Application for a non-material amendment following a grant of planning permission.

Number	120
Suffix	
Property name	
Address line 1	Laund Road
Address line 2	Salendine Nook
Address line 3	
Town/city	Huddersfield
Postcode	HD3 3TY

Demolition of Existing Dwelling and erection of 7 No. Dwellings	
Reference number:	2019/90486
Date of decision	12/06/2020

Raise Plot 2 by 350mm

PLOT 2 ELEVATIONS

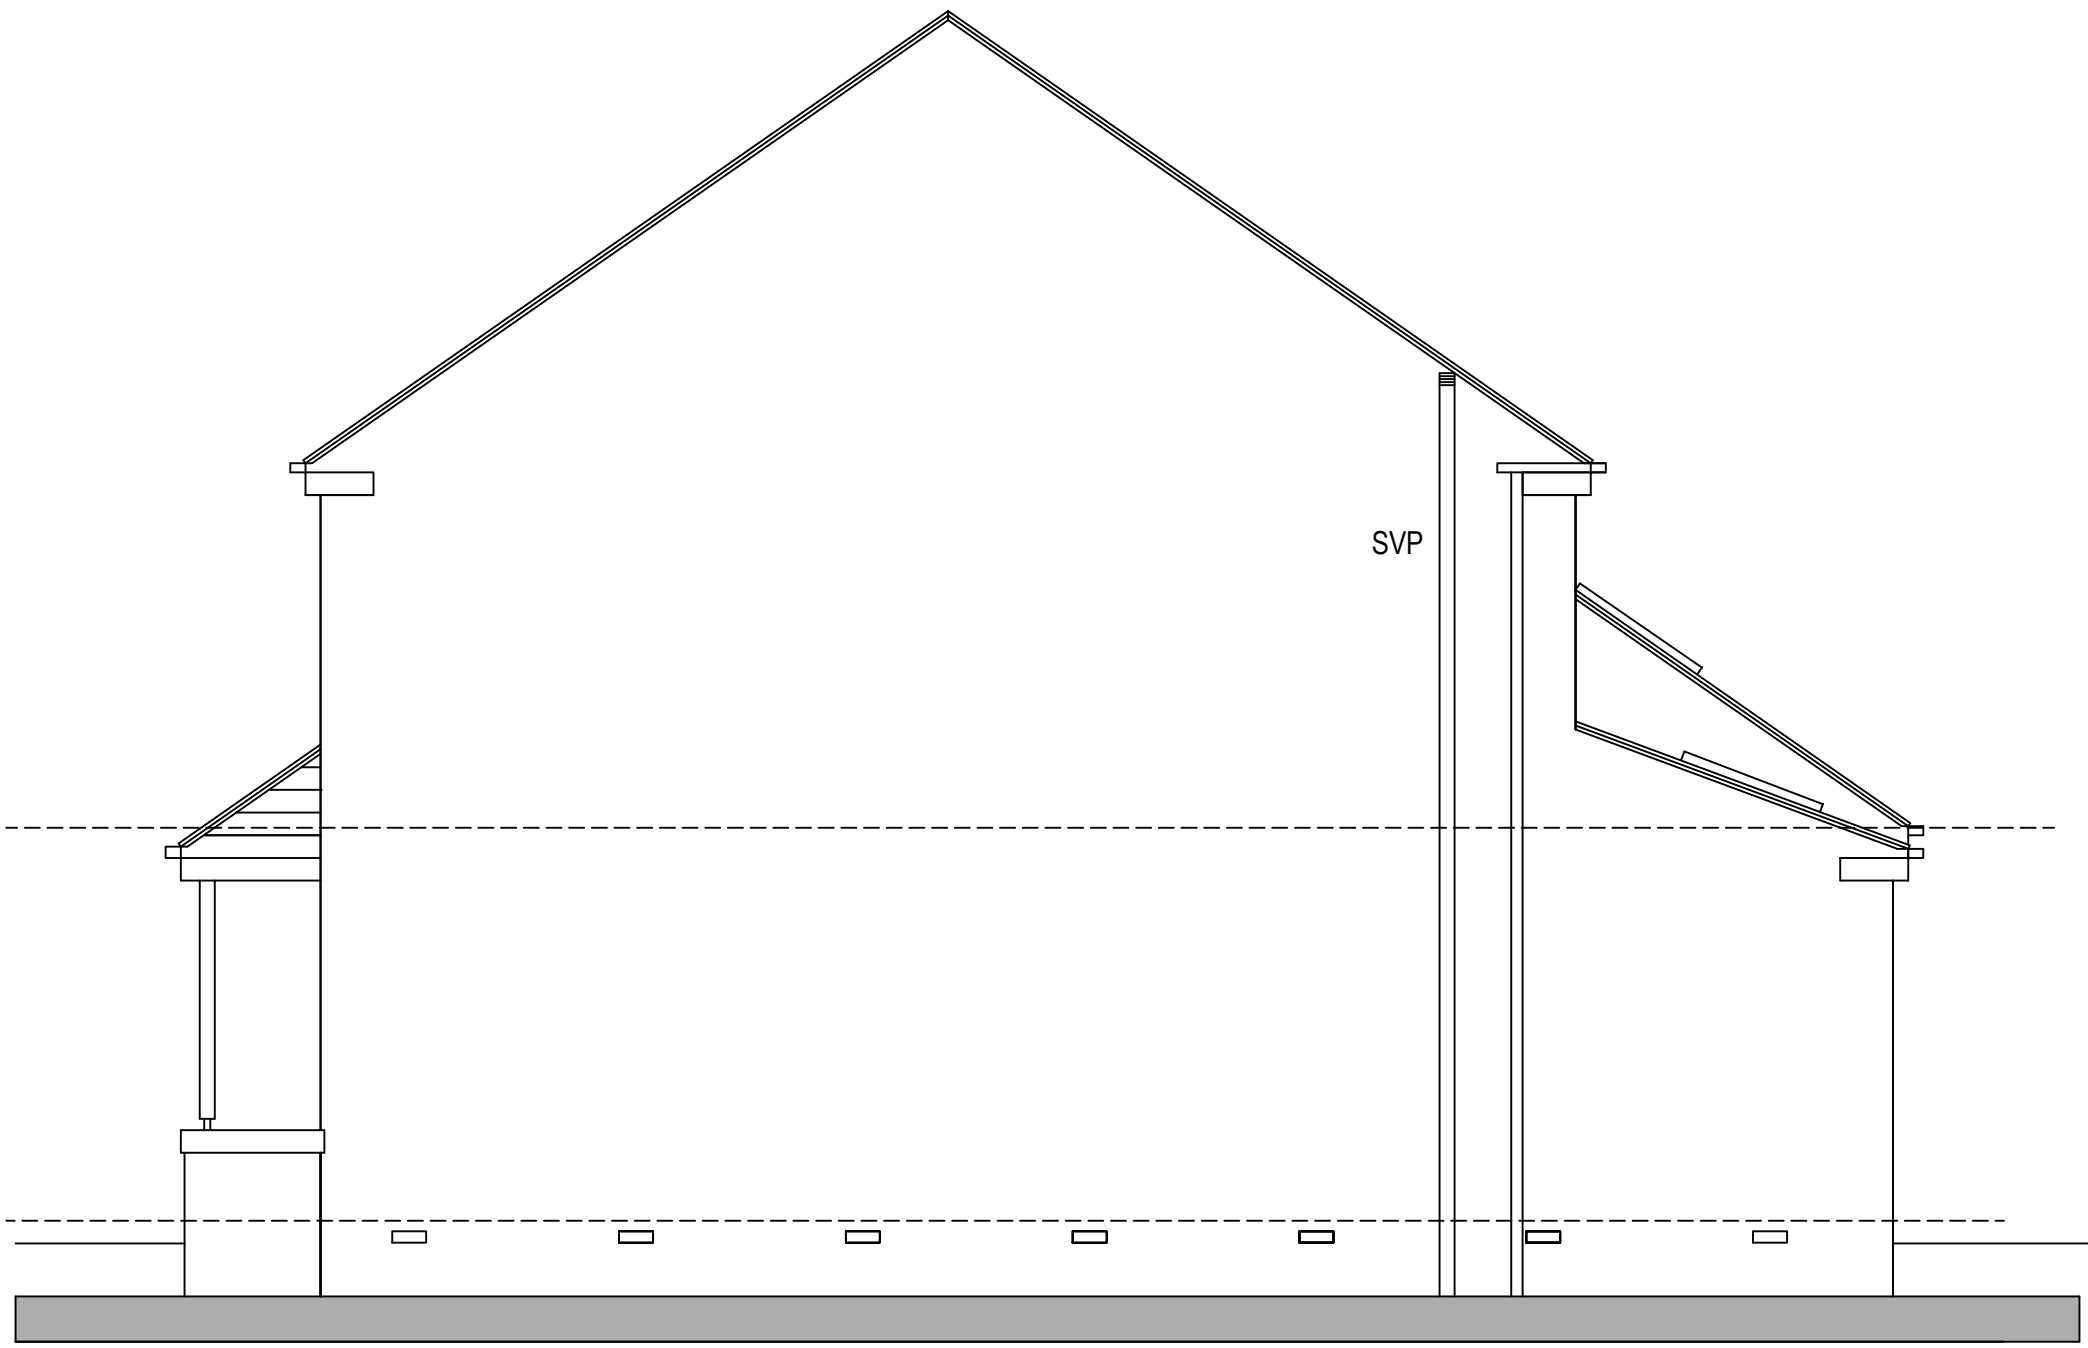
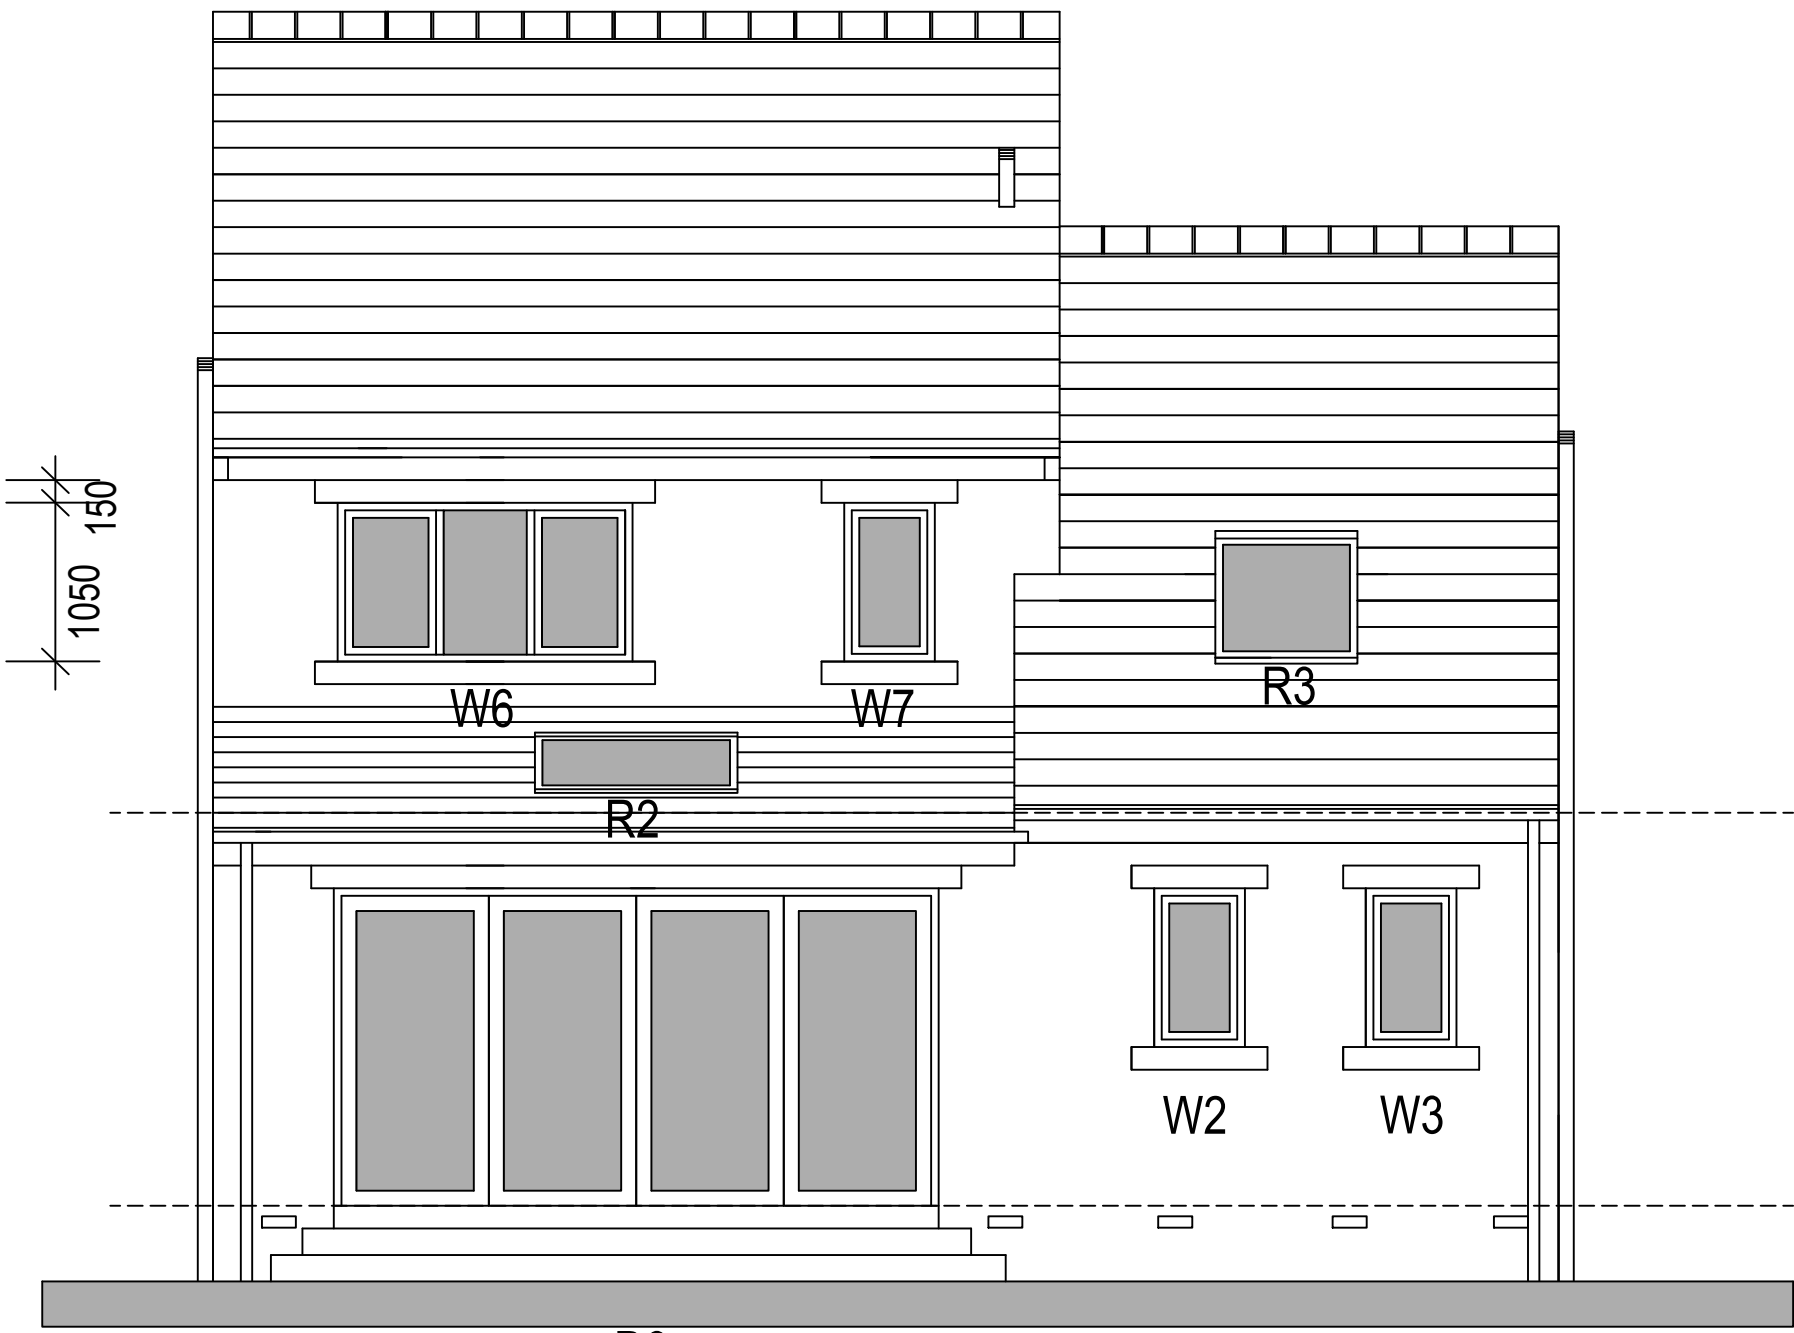
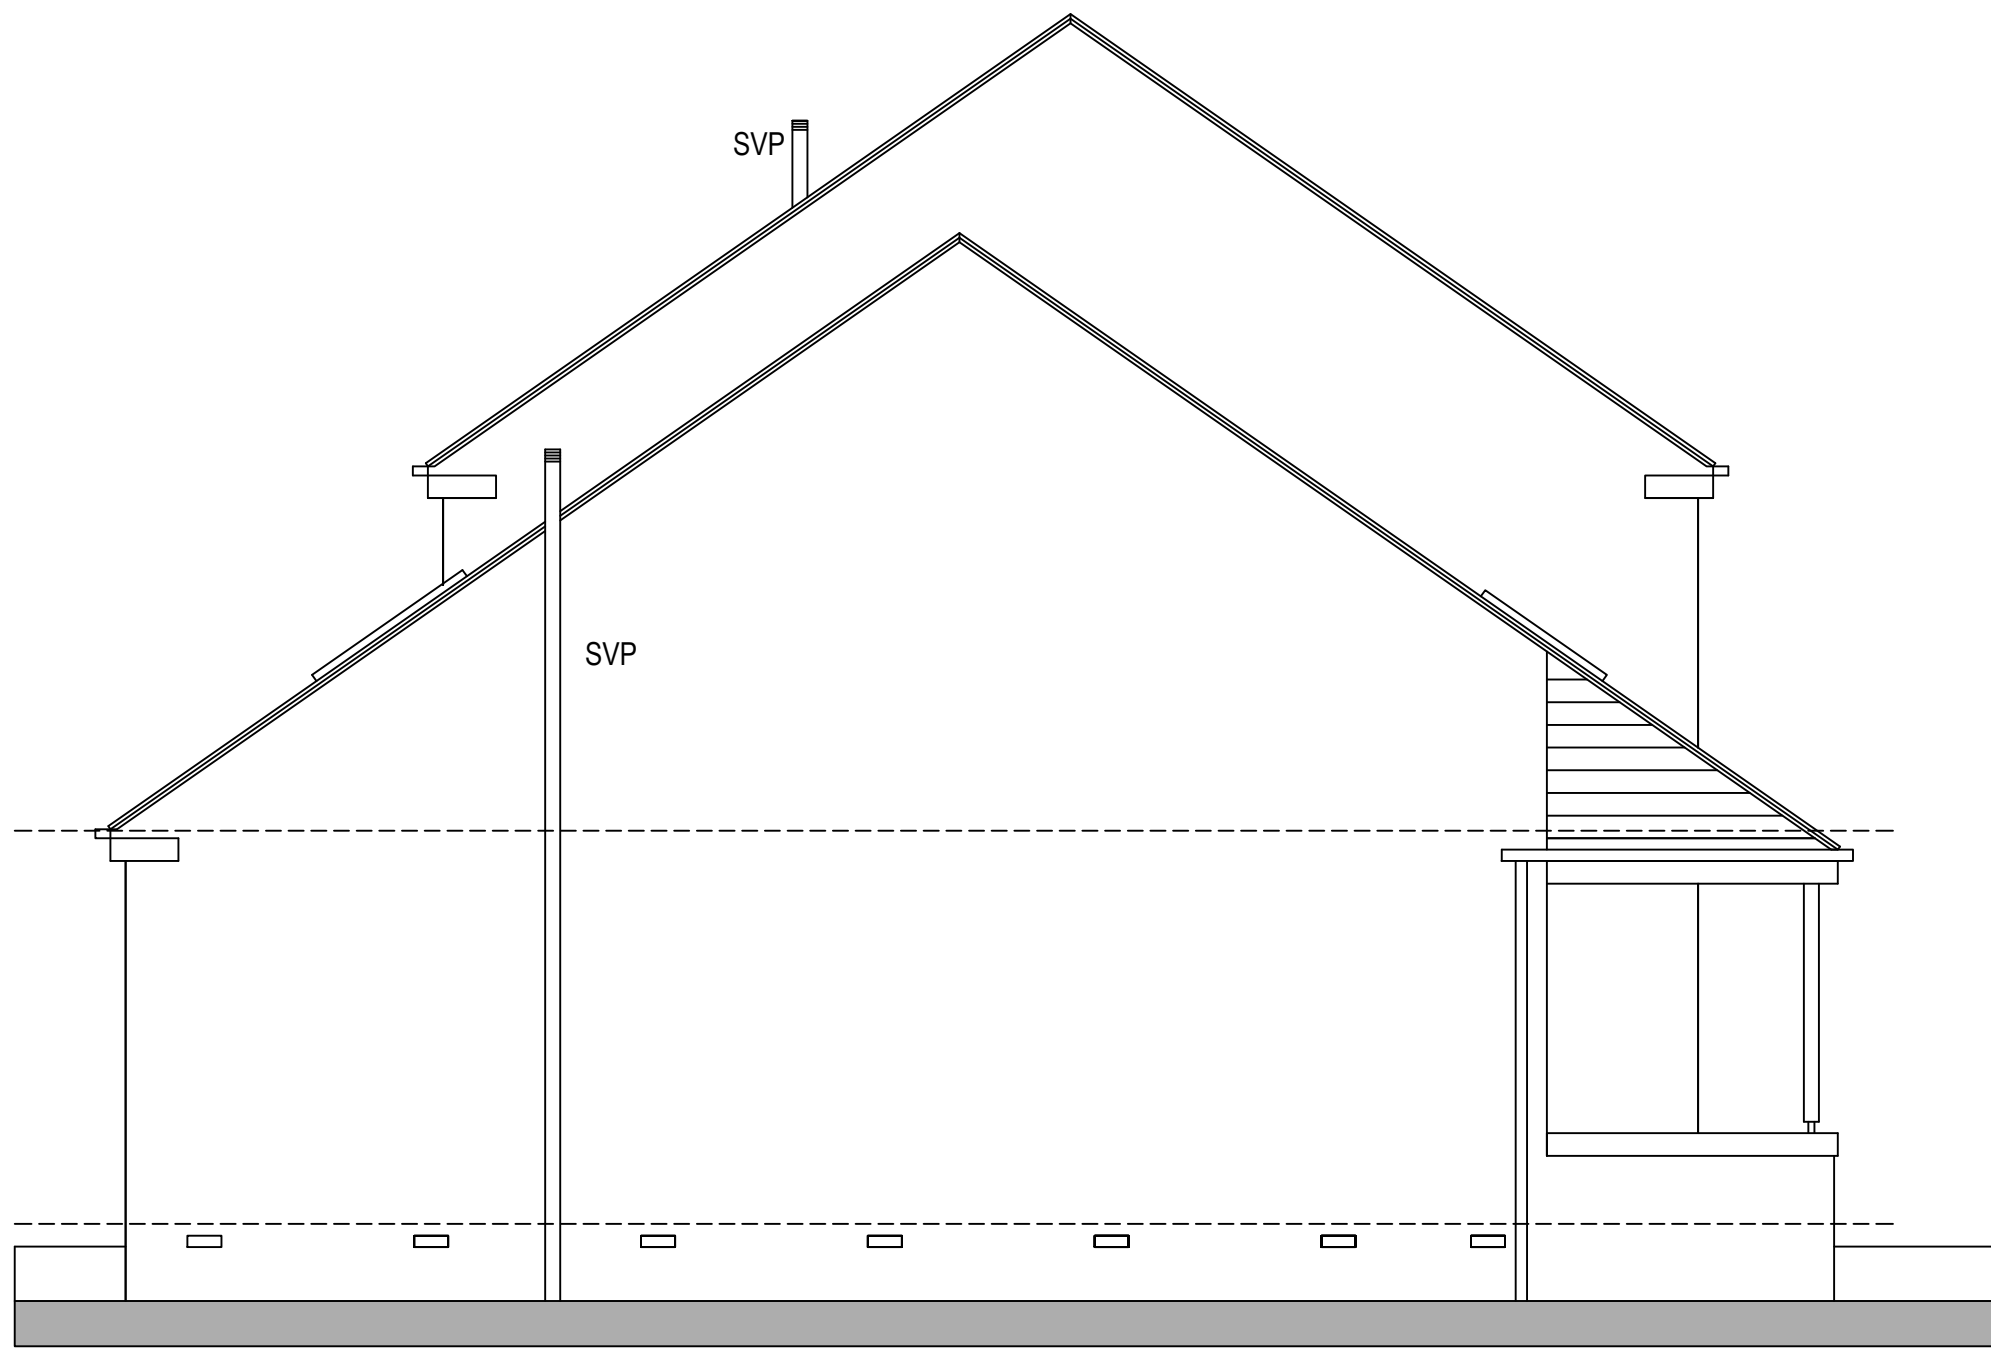
Due to the floor construction changing, from solid to suspended beam and block, due to incorporation of gas membrane
